Martin Nugent
01254 828060
D3/12/0233

Drafted 10 April 2012

**Planning Application, Ribble Valley District
D3-12-0233 Waddington Old Mill, Waddington**

Site Plan (1:250)

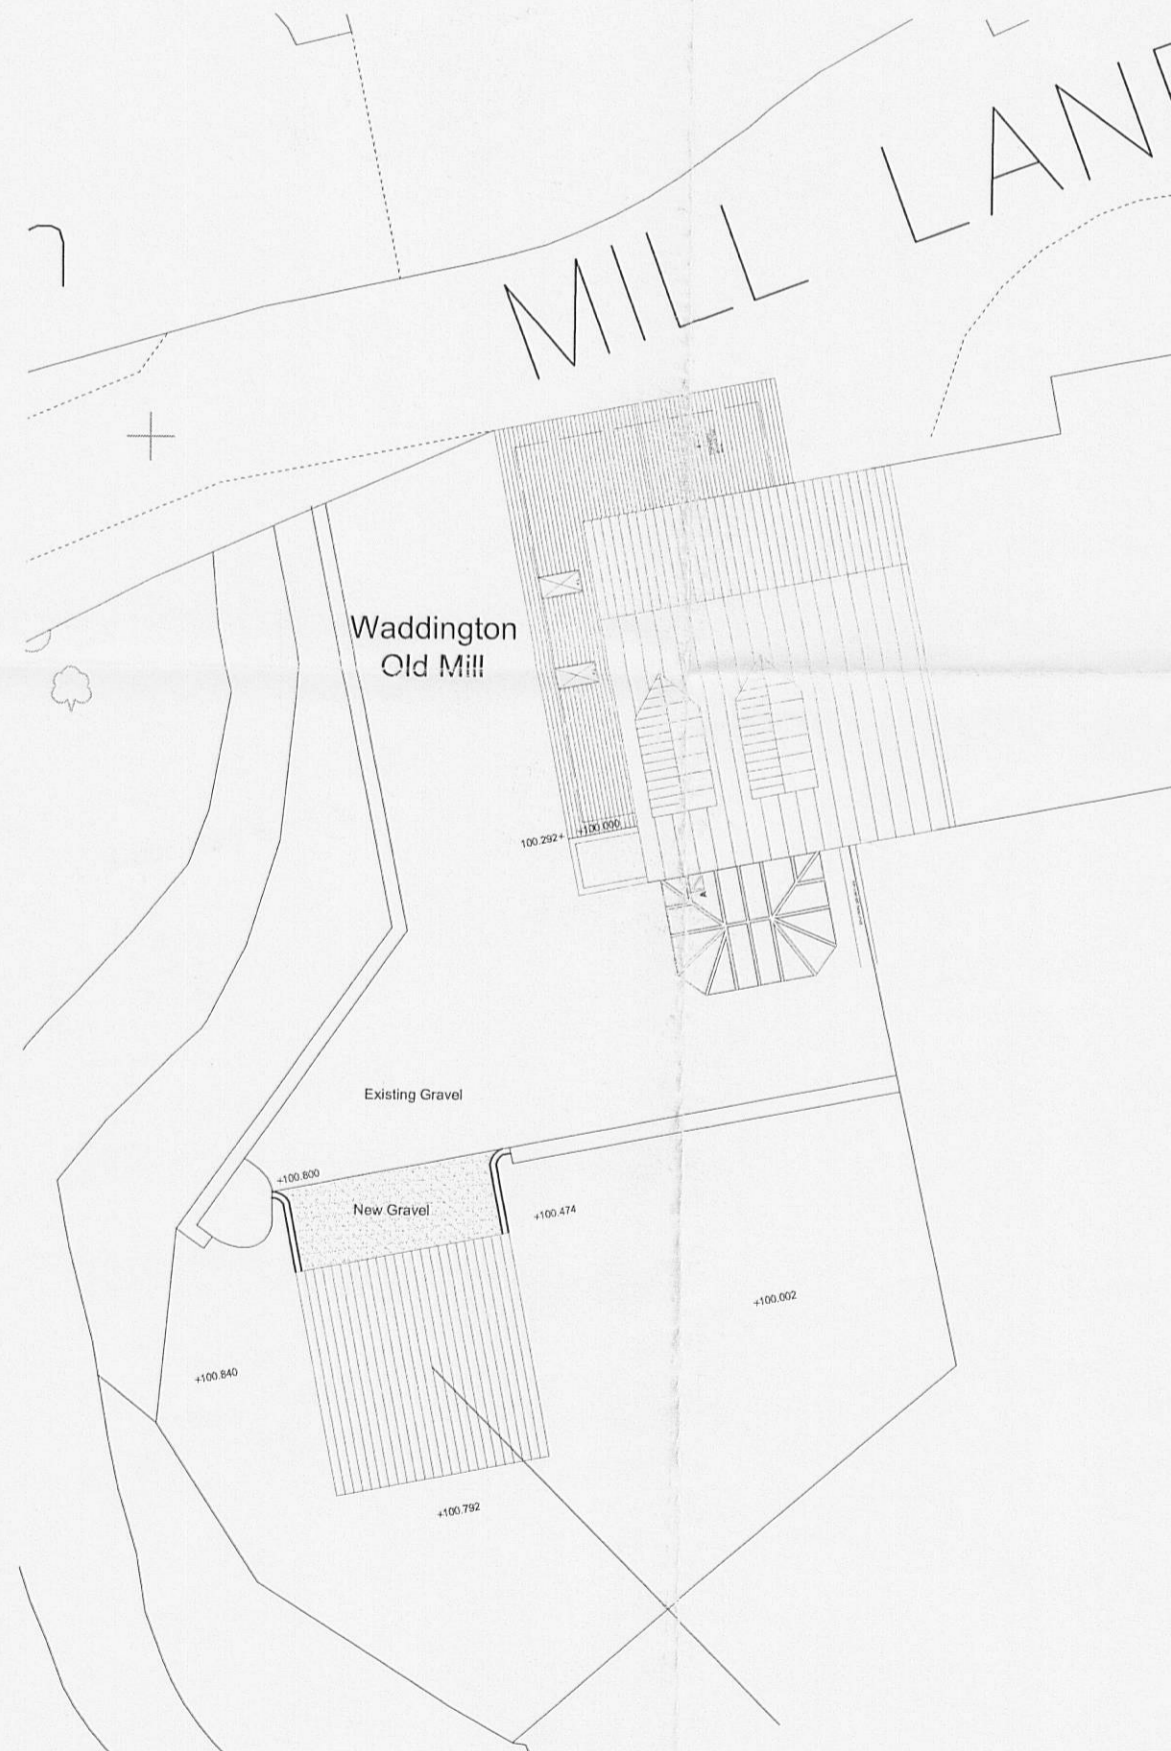
The development offers sufficient off street parking for at least three vehicles, through a combination of the detached double-garage and substantial driveway.
